30 Merrill Street - Preliminary Traffic Comments

Hi Nell – I have reviewed the application materials and offer the following preliminary traffic comments.

DRIVEWAY APRON LAYOUT
NOT TO SCALE

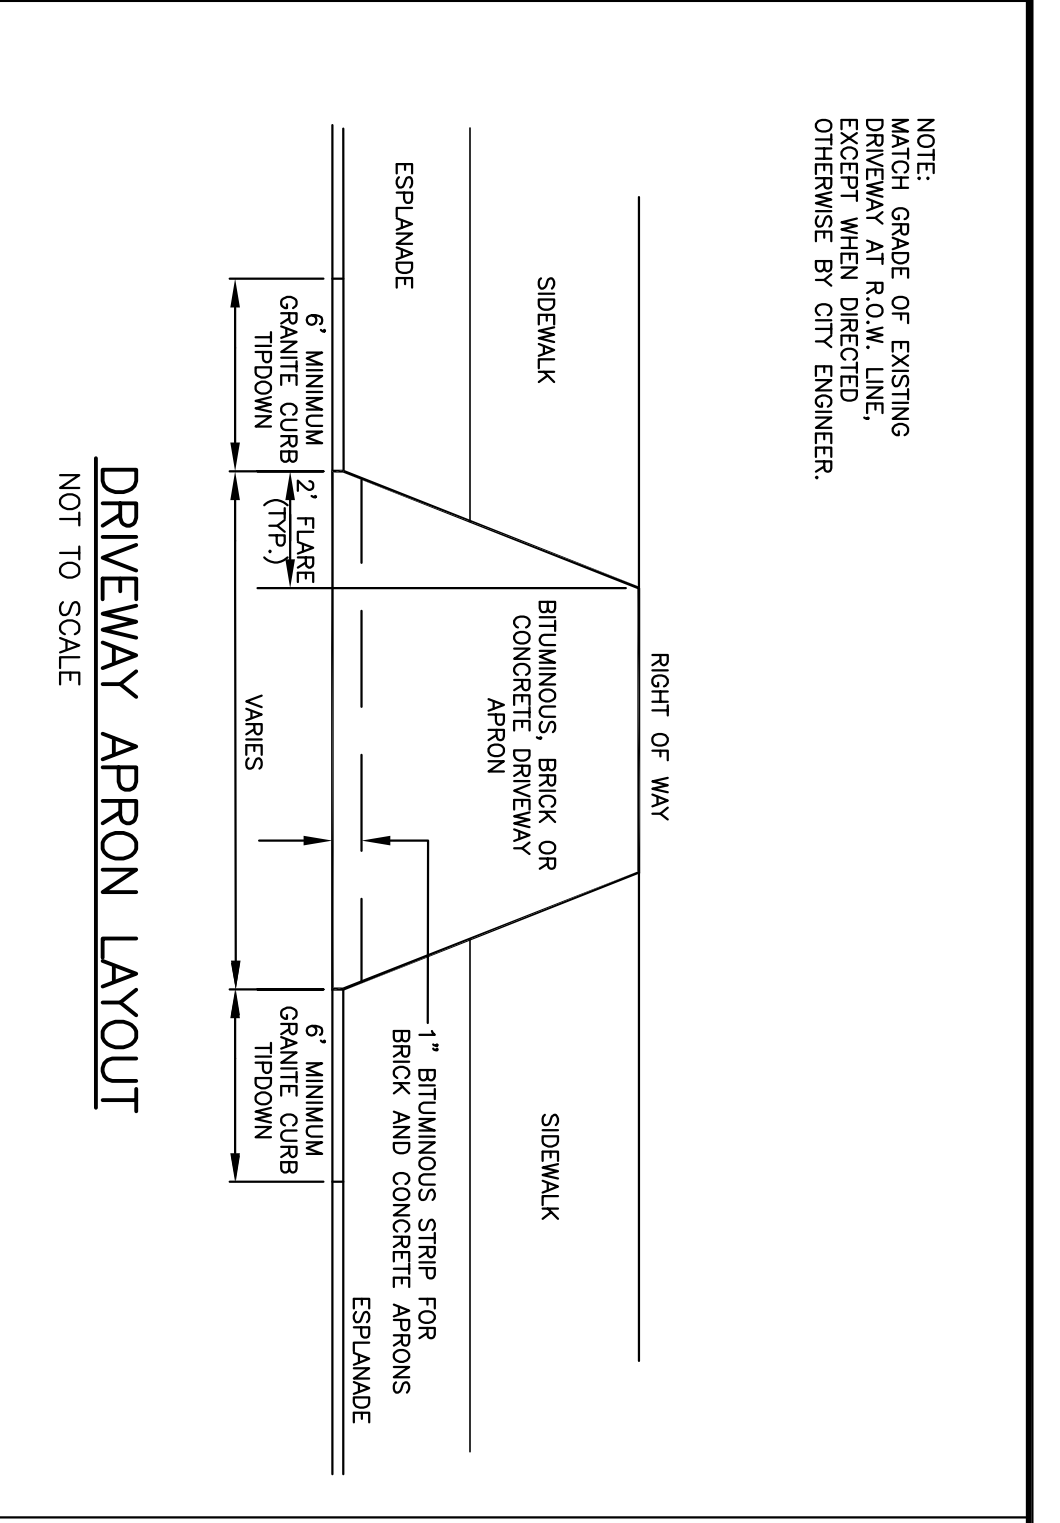
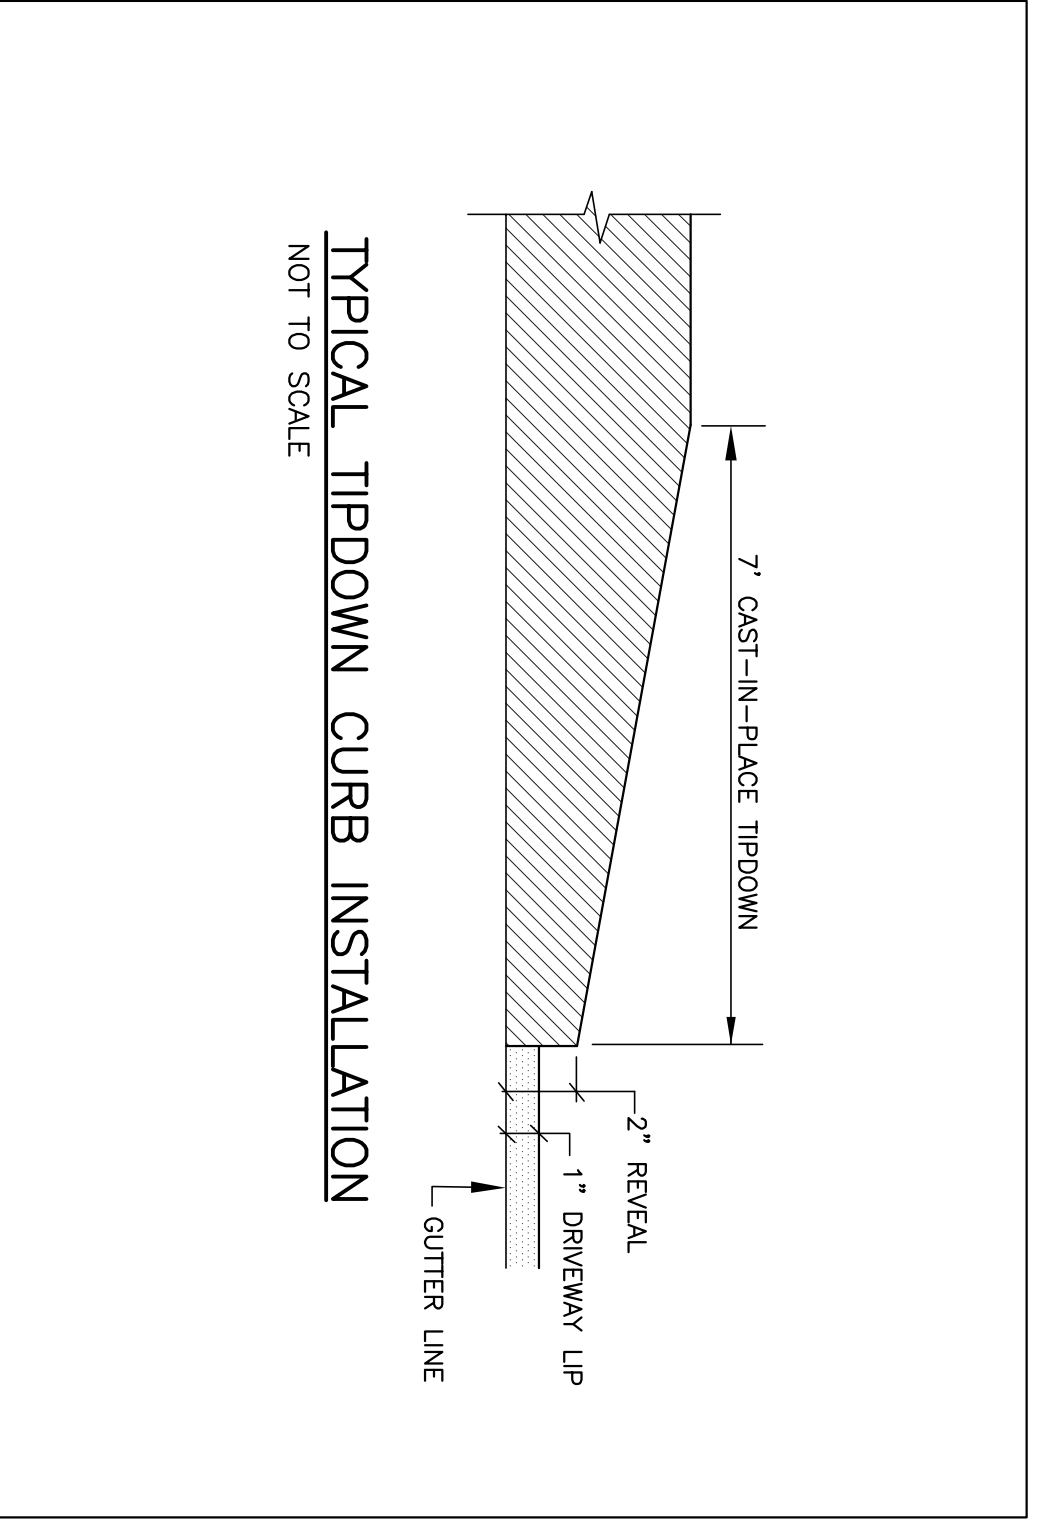
- The site plan depicts the driveway offset from the curb opening, while the existing driveway is centered. The applicant should note why an offset condition is proposed.
- The applicant should formally request a waiver from the City's driveway separation standard and provide documentation on why the standard can't be met.
- A fence is proposed on the edge of the driveway. Details on the fence should be provided.
- Access and egress movements from parking spaces will be constrained. The applicant has provided vehicle turning templates that seem to illustrate parking space accessibility is feasible. Given the constrained conditions, I would suggest the applicant simulate the layout in a field test to be reviewed by me. I would note that the parking space adjacent to the handicap space will be difficult to maneuver into and out of.
